CITY OF ALBUQUERQUE

July 7, 2021

**Re; Lot 9, Blk 13 Volcano Cliffs SAD 227
6519 Jade NW
Grading and Drainage Plan for Pool
Engineers Stamp Date: 6/26/2021 E10D062**

TITLE:			
GRADING PLAN			
Design Review Committee	City Engineer	Mo./Day/Yr.	Mo./Day/Yr.
City Project No.	Zone Map No.	Sheet	Of
	E-10-Z	1	2

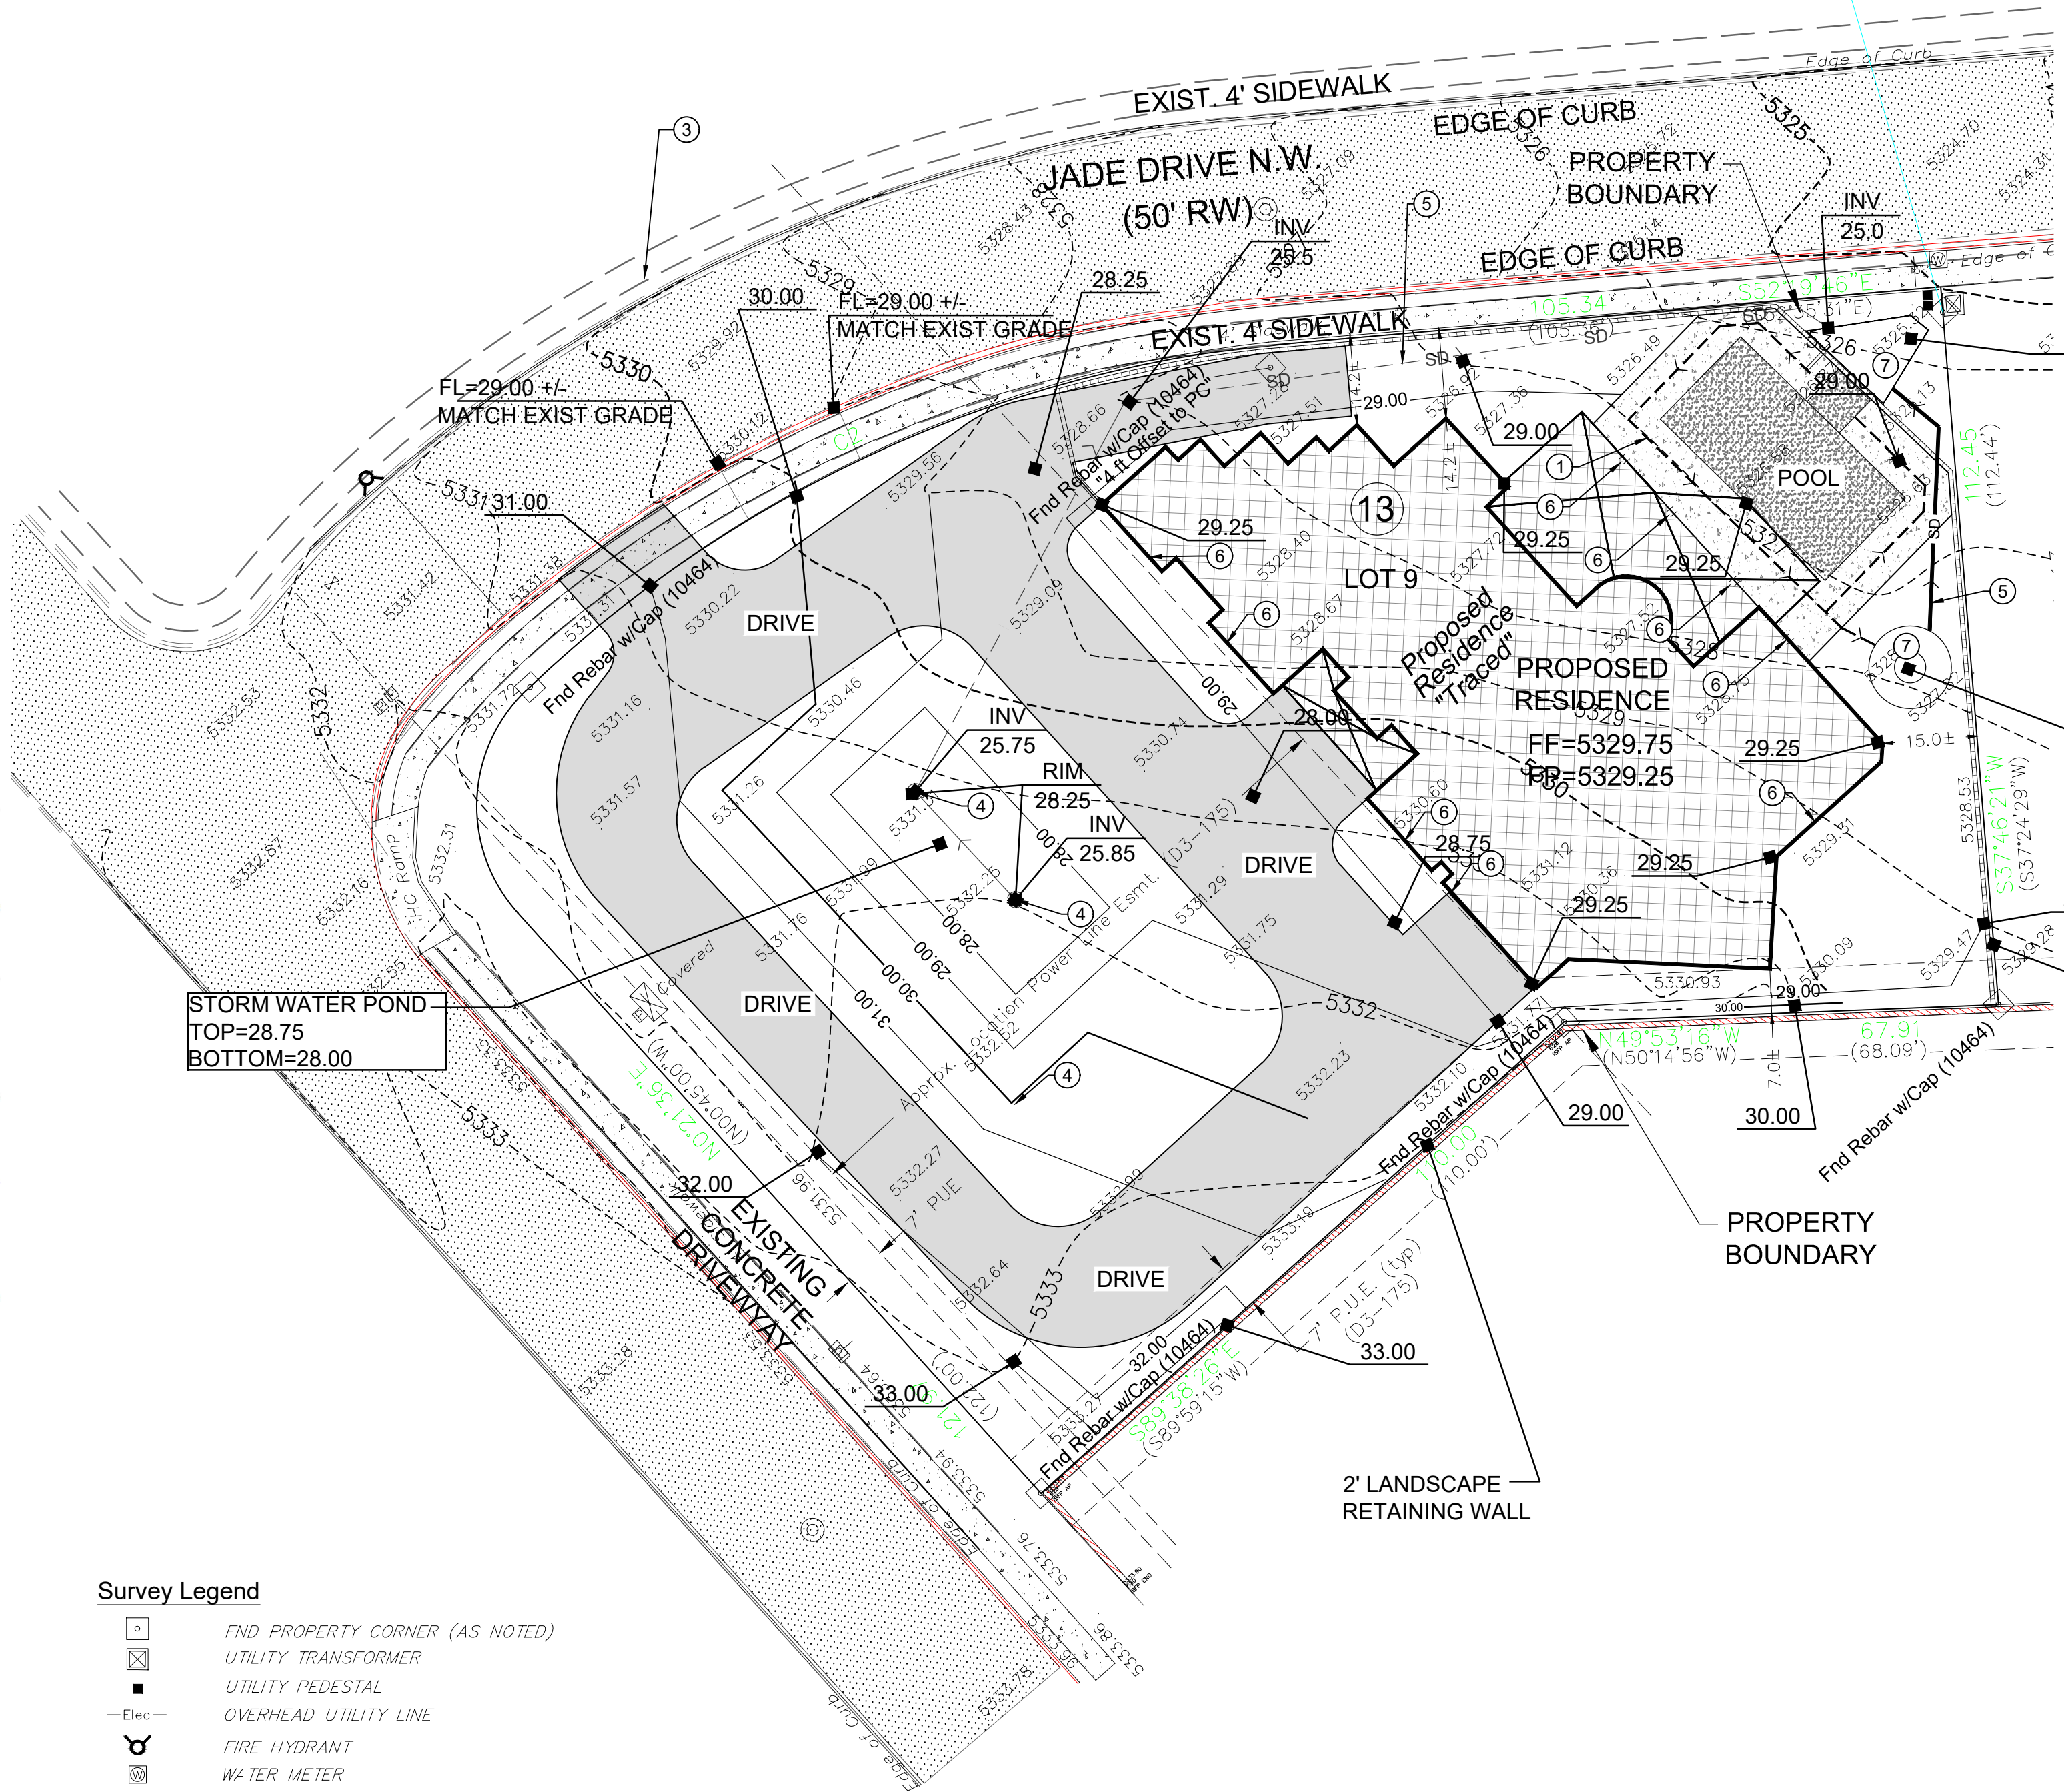
- The pool needs to be placed on the approved G&D plan. If you wish for the pool to be separate from the original G&D a CO must be approved on the original permit.
- Provide a table of the land treatments.
- Provide if the ponding areas should keep the same capacity or a greater capacity. The pool is located where the original ponding area was required.
- Provide the outlet spot elevation for the pond when overflowing.
- Provide erosion control for the pond.
